November 17, 2022

Project: GAAR 1635 University Blvd. Renovation and Addition-Permit Reference H15-D008

Subject: Reference Letter dated November 7, 2022-Traffic Circulation Layout Review

A1 TRAFFIC PLAN
1" = 40'-0"

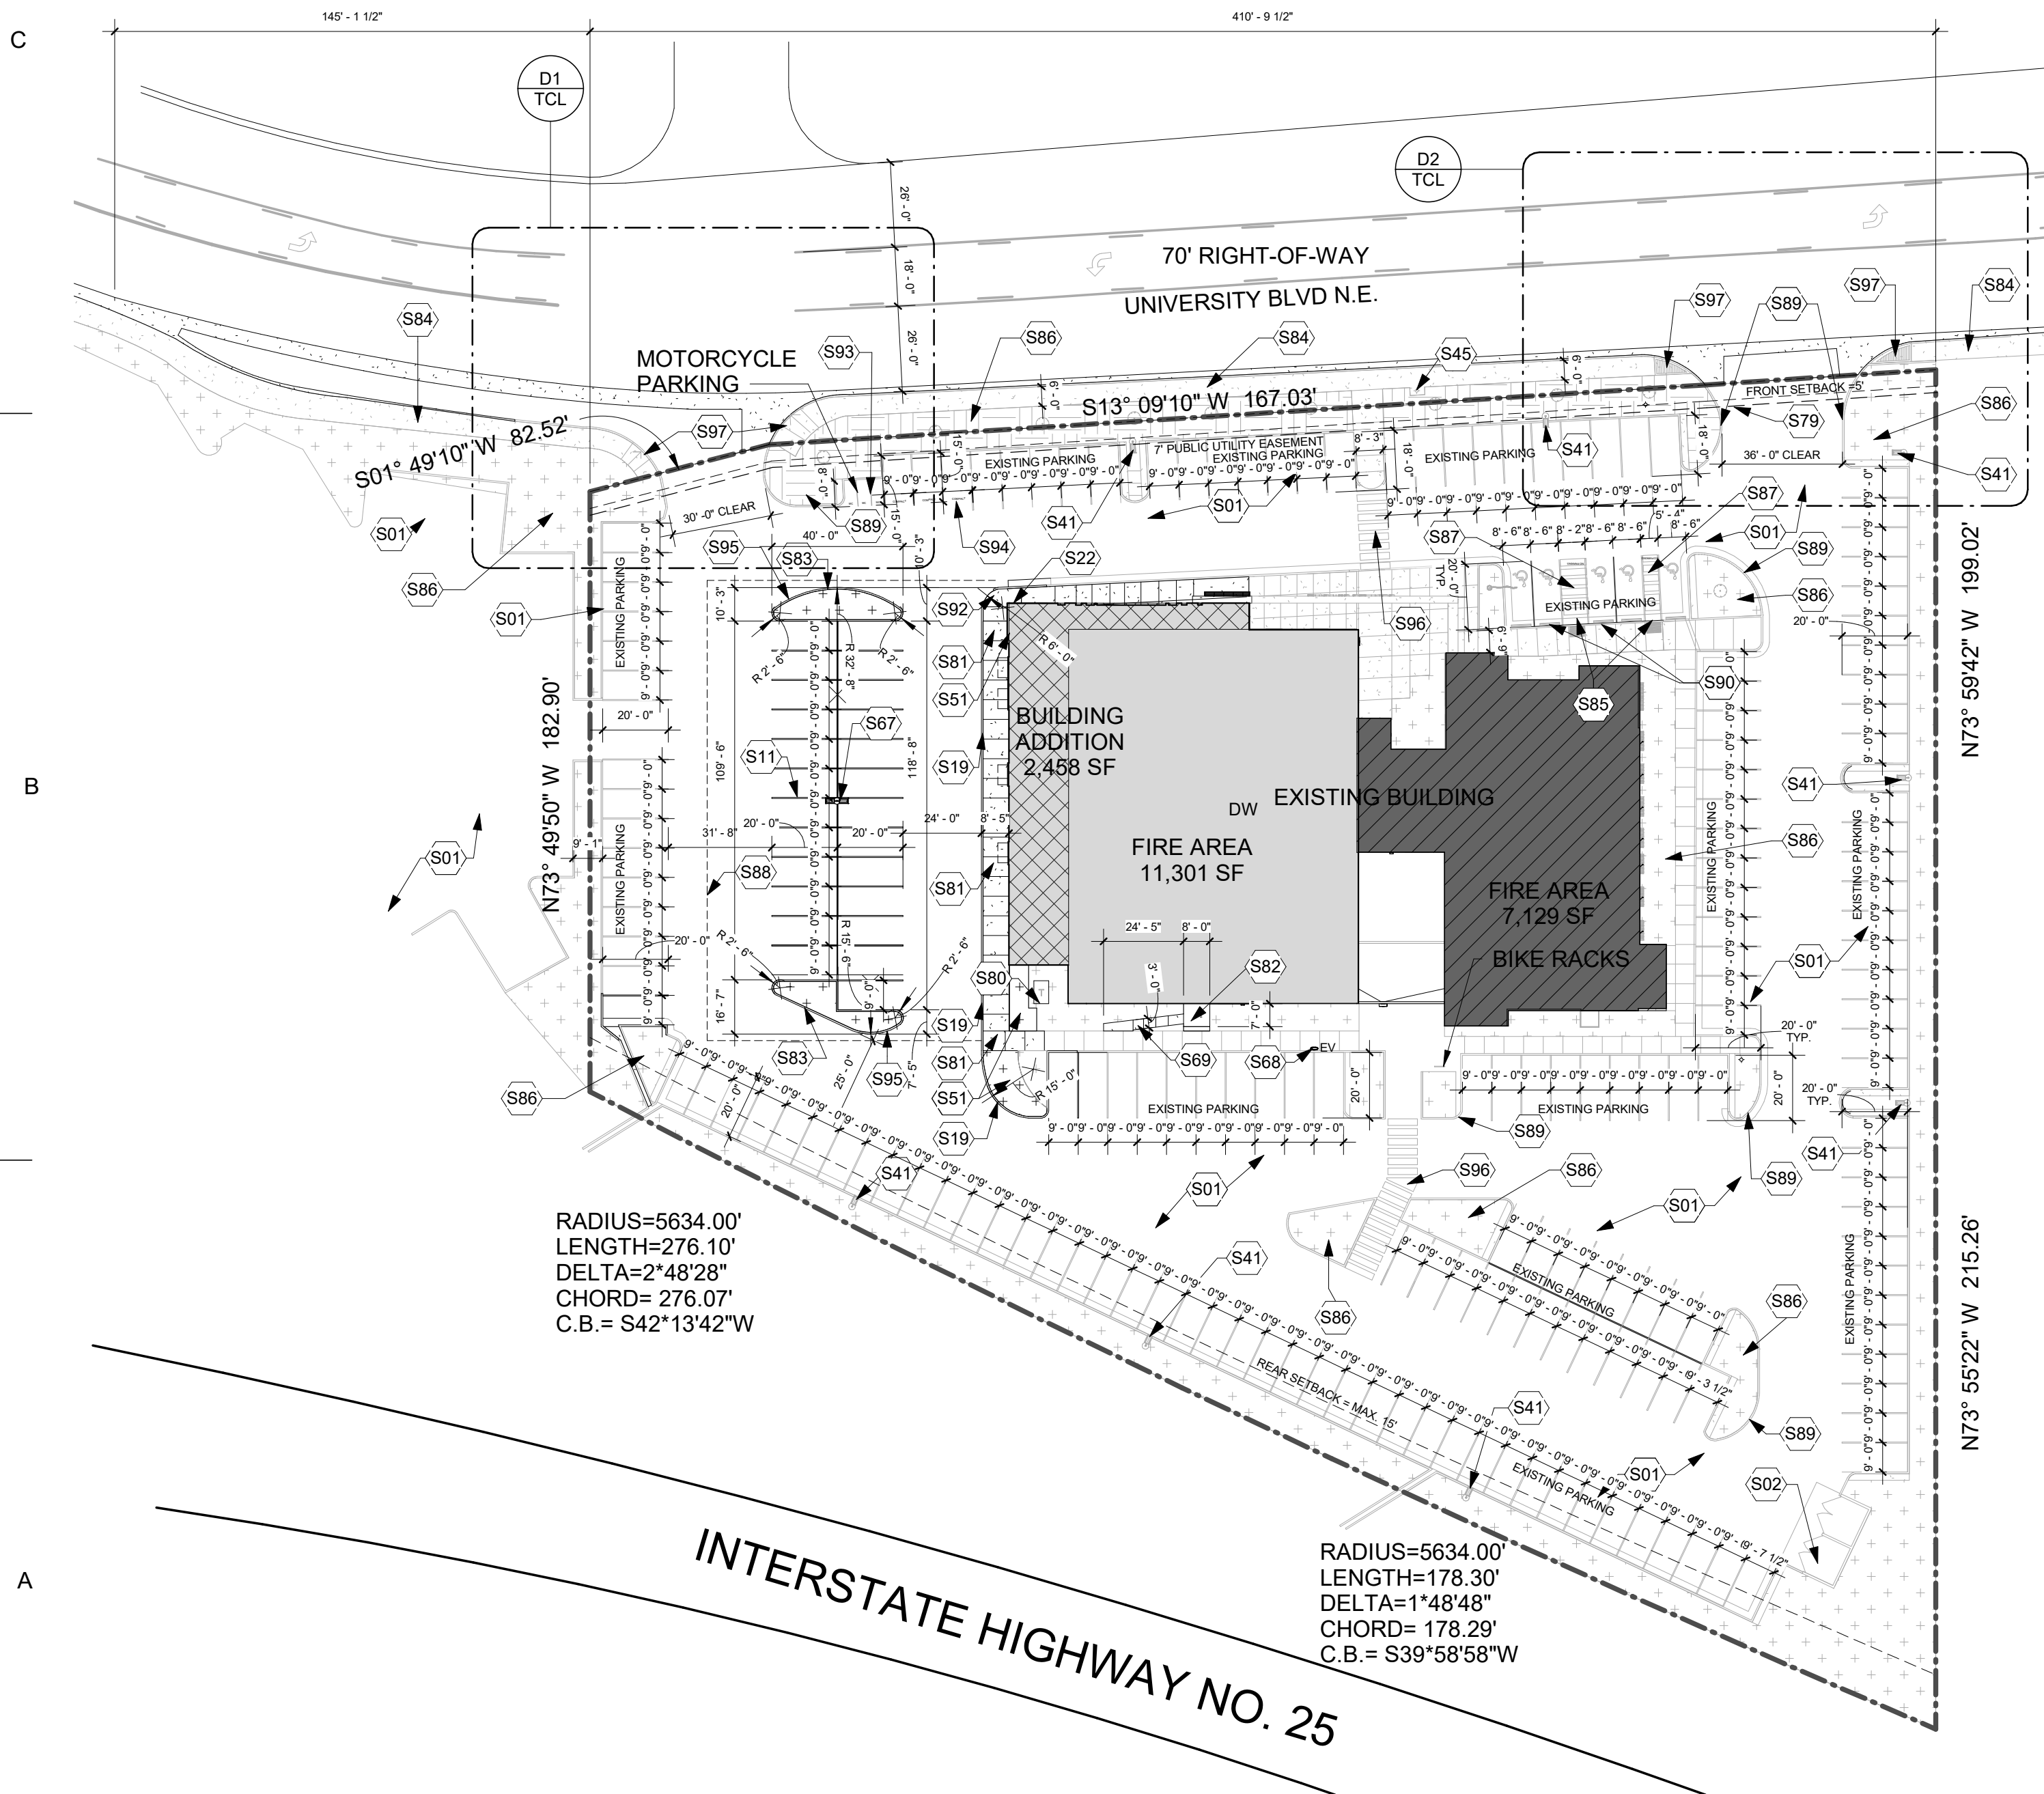
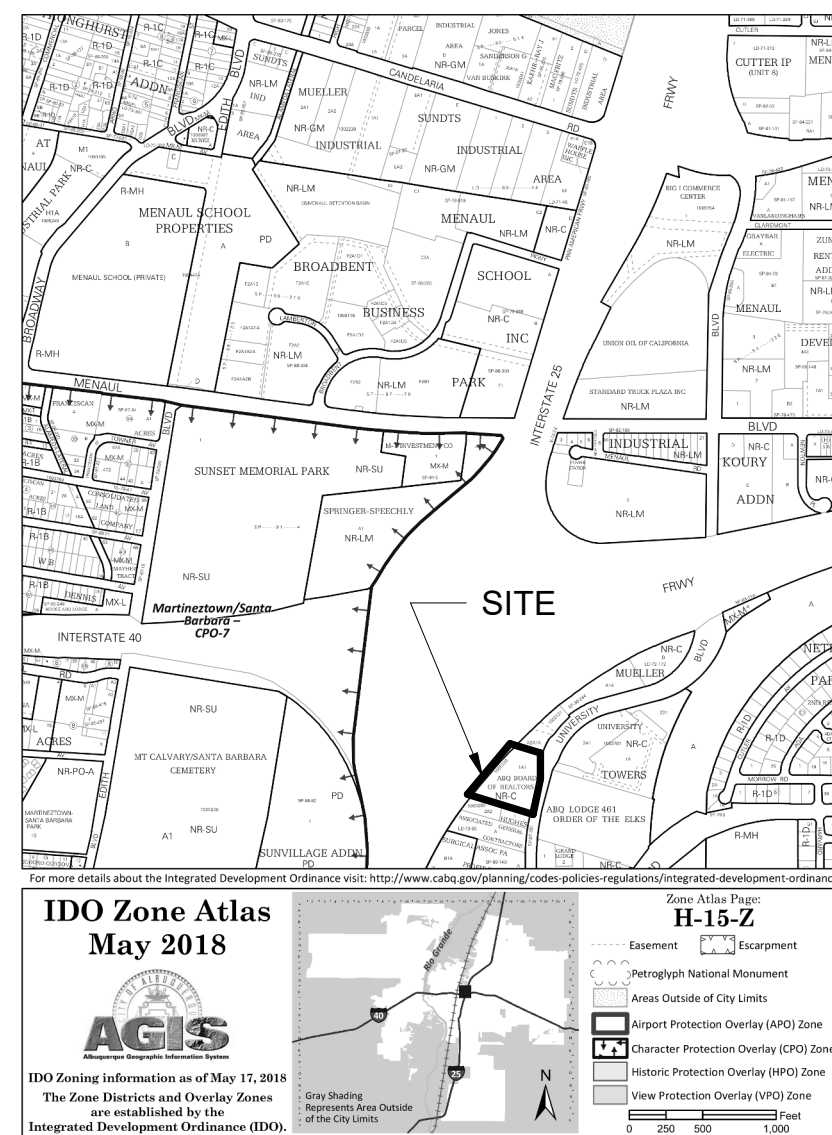
1. Label the compact parking spaces by placing the words **"COMPACT"** on the pavement of each space.  
RESPONSE: Stenciled lettering on the asphalt paving to read "COMPACT" shall be added as part of the project and as shown in the revised TCL Plan.

3. Key note S69: The minimum width for the pathway should be 4 ft.  
RESPONSE: New pathway shall be adjusted to 4 ft as shown on the revised TCL.
4. Key note S81: Call out COA std dwg 2430.

RESPONSE: Added face sign details on sheet TCL2.
7. Key note S96: Per the IDO, a 6 ft. wide ADA accessible pedestrian pathway is required from the public sidewalk to the building entrances. Please clearly show this pathway and provide details.

10. Show all drive aisle widths and radii. Some dimensions are not shown.

12. Per DPM, a 6 ft. wide ADA accessible pedestrian pathway is required from the ADA parking stall access aisles to the building entrances. Please clearly show this pathway and provide details.

RESPONSE: Hatched pathway added on TRAFFIC PLAN to reflect existing condition.

Response: Dimensions have been added on revised TRAFFIC PLAN, TCL1.

RESPONSE: Hatched pathway has been added on TRAFFIC PLAN. Also illustrated below.
